Application number: 2019/90725	
What is the application for?:	Demolition of existing dwellings and erection of 9 apartments
Address of the site or building:	Land at, Busker Lane, Scissett, Huddersfield, HD8 9JU
Postcode:	N21 2QP

Type of comment: An objection
<p>My objections and observations are as follows:</p> <ol style="list-style-type: none"><li>1. Development plan policies, supplementary planning guidance and other planning policies</li></ol> <p>The most recent Kirklees Local Plan was adopted on 27 February 2019. One of the factors considered relevant during the consultation process prior to adoption was the presence of a Grade II Listed Building. Both the Council and Historic England consider that the open areas around the Listed Building are of high significance to its setting, limiting potential for development in a manner which would be consistent with the appropriate conservation of this designated heritage asset. The location of the proposed apartments is immediately adjacent to a Grade II Listed Building and neither their location nor their size, height and appearance is consistent with the appropriate conservation of a heritage asset.</p> <ol style="list-style-type: no

Proposed Elevation 1: Front Elevation Facing Busker Lane  
Scale 1:100

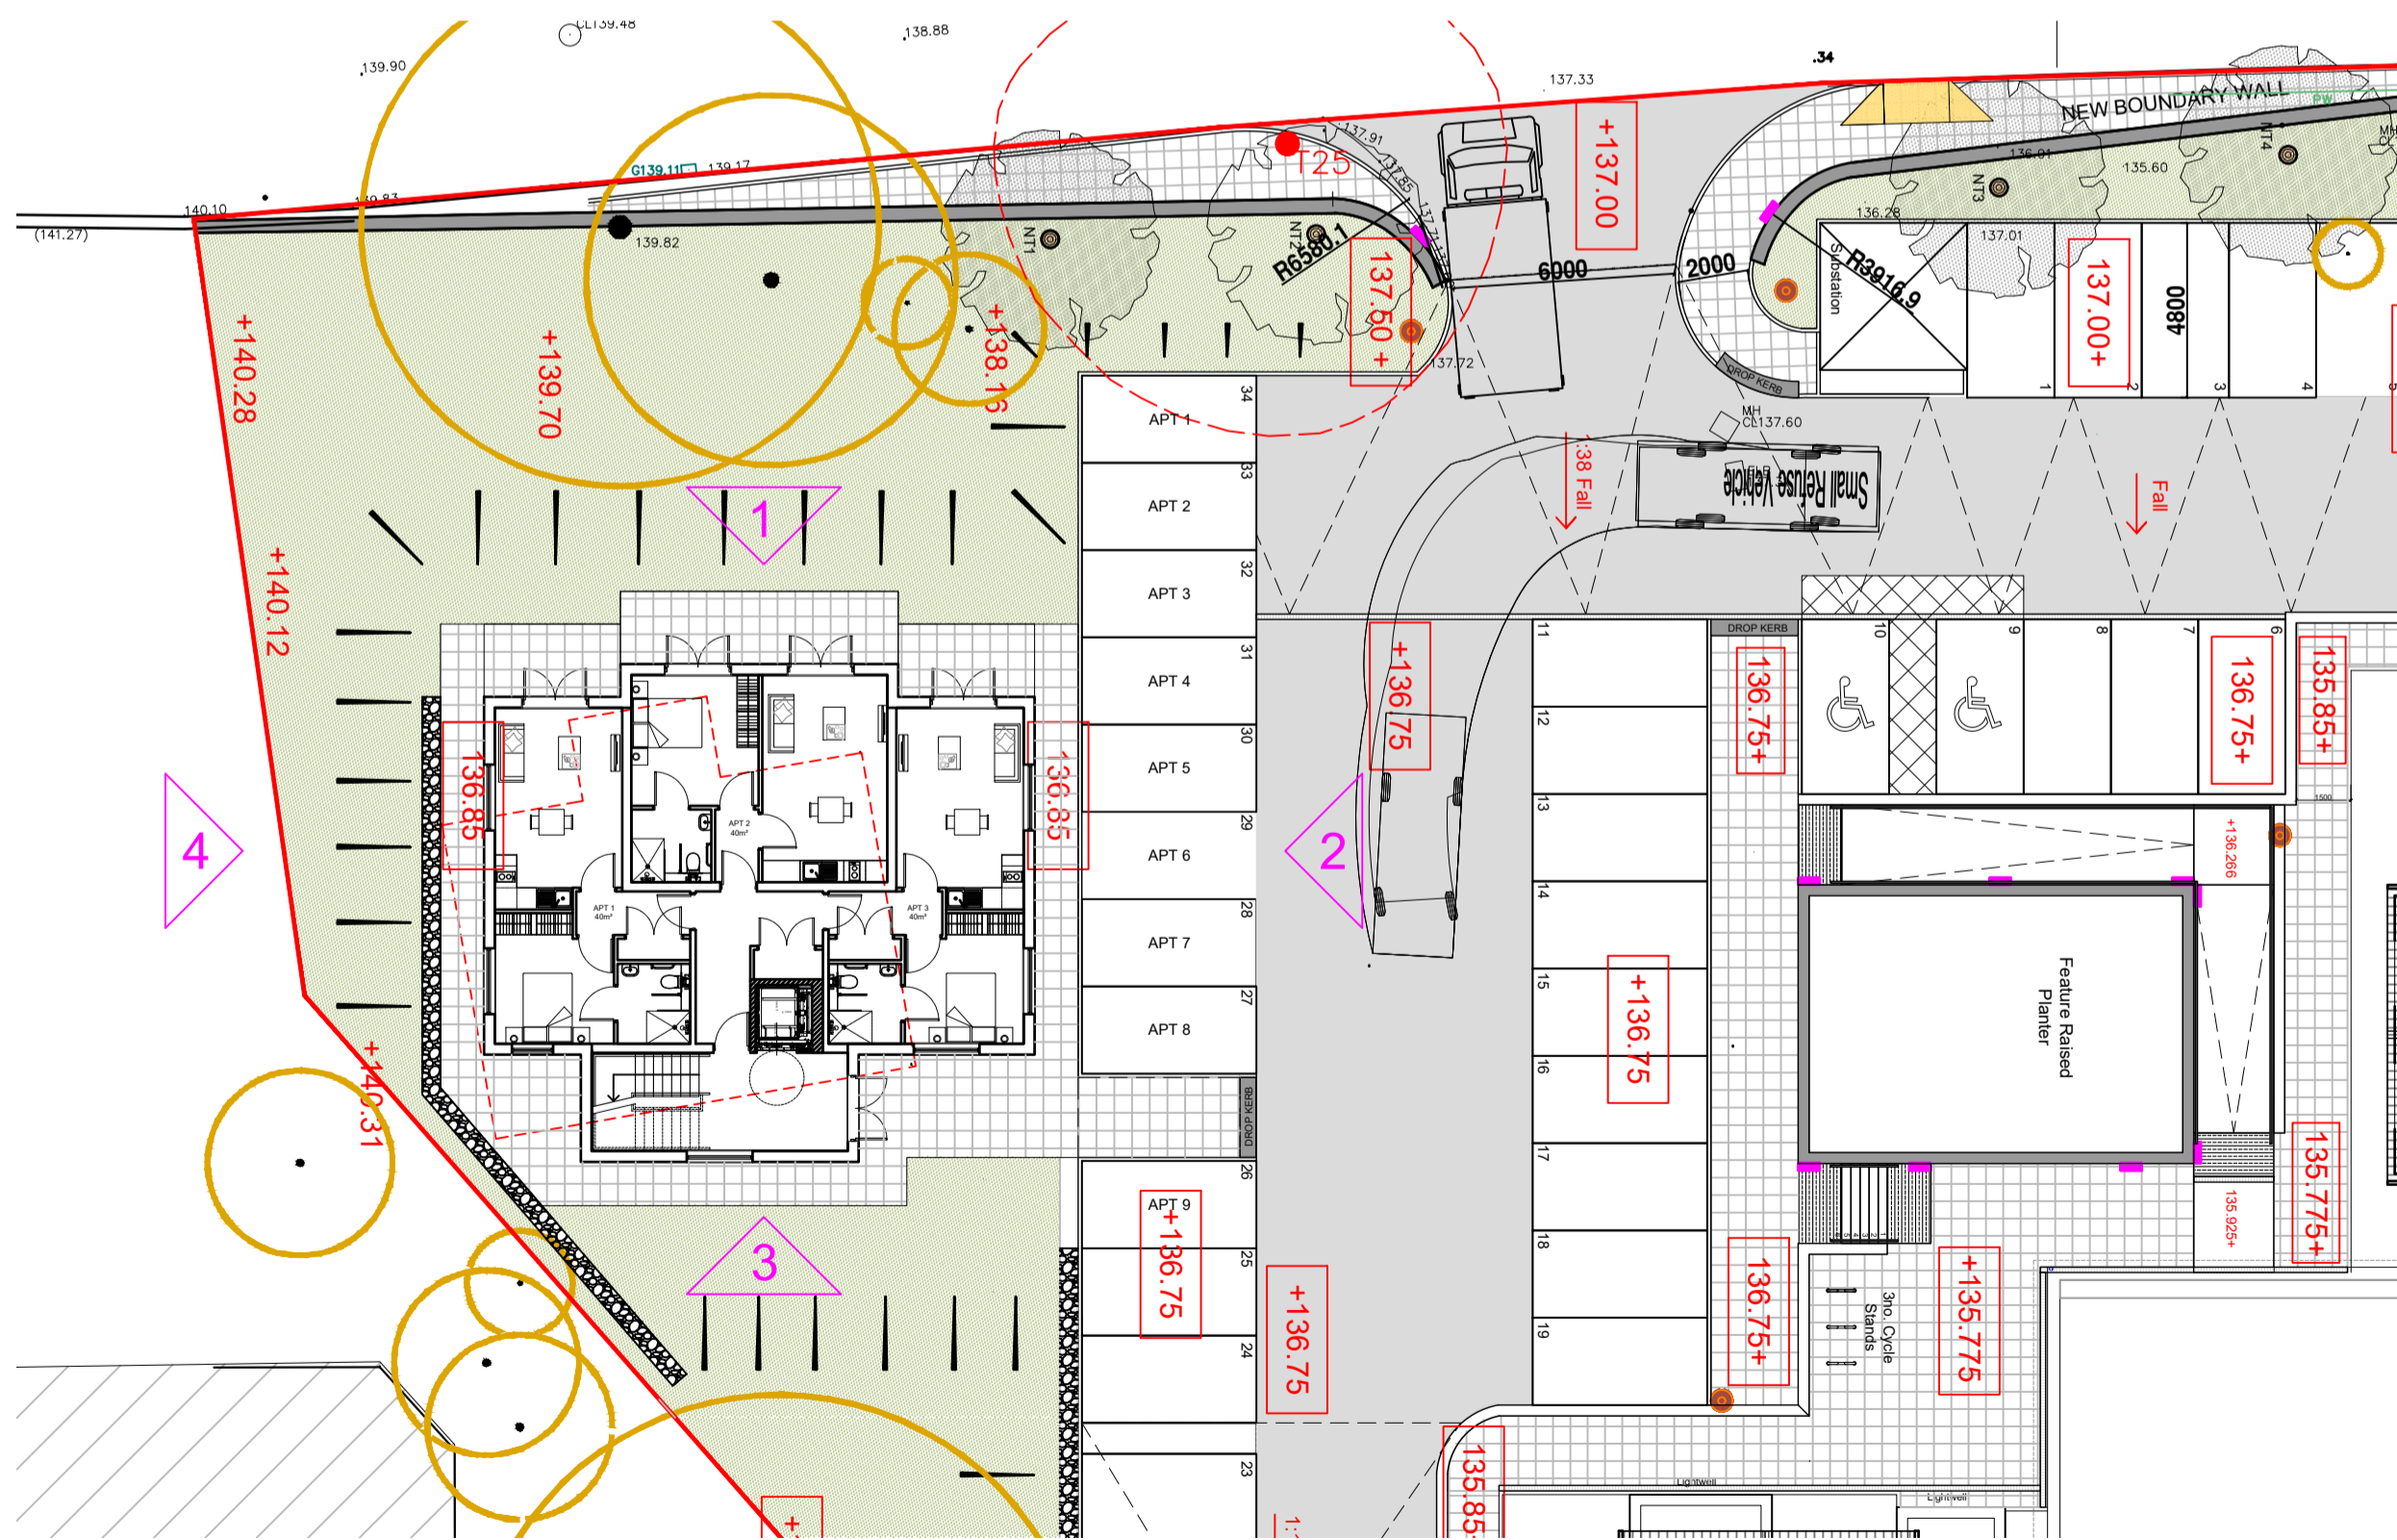
The proposed group plans and elevations depict a misleadingly arboreal proposed street view from Busker Lane. As a site inspection will reveal, the reality on the ground is quite different. The care home as built, and the apartments as proposed, are open, overbearing and stark, and damage the visual amenity of Busker Lane and of the residential properties immediately across the road (which include a Grade II Listed Building). Any additional permission now granted should include detailed conditions for the extensive landscaping and screening of the care home and apartments pursuant to the existing planning permission.

Incidentally, the proposed street view from Busker Lane is also misleading in that it does not show the substation which has already been built, for which there is no provision in the existing planning permission and which is therefore in breach of the existing planning permission. If it is allowed to remain in place it should also be extensively screened with evergreen plants.
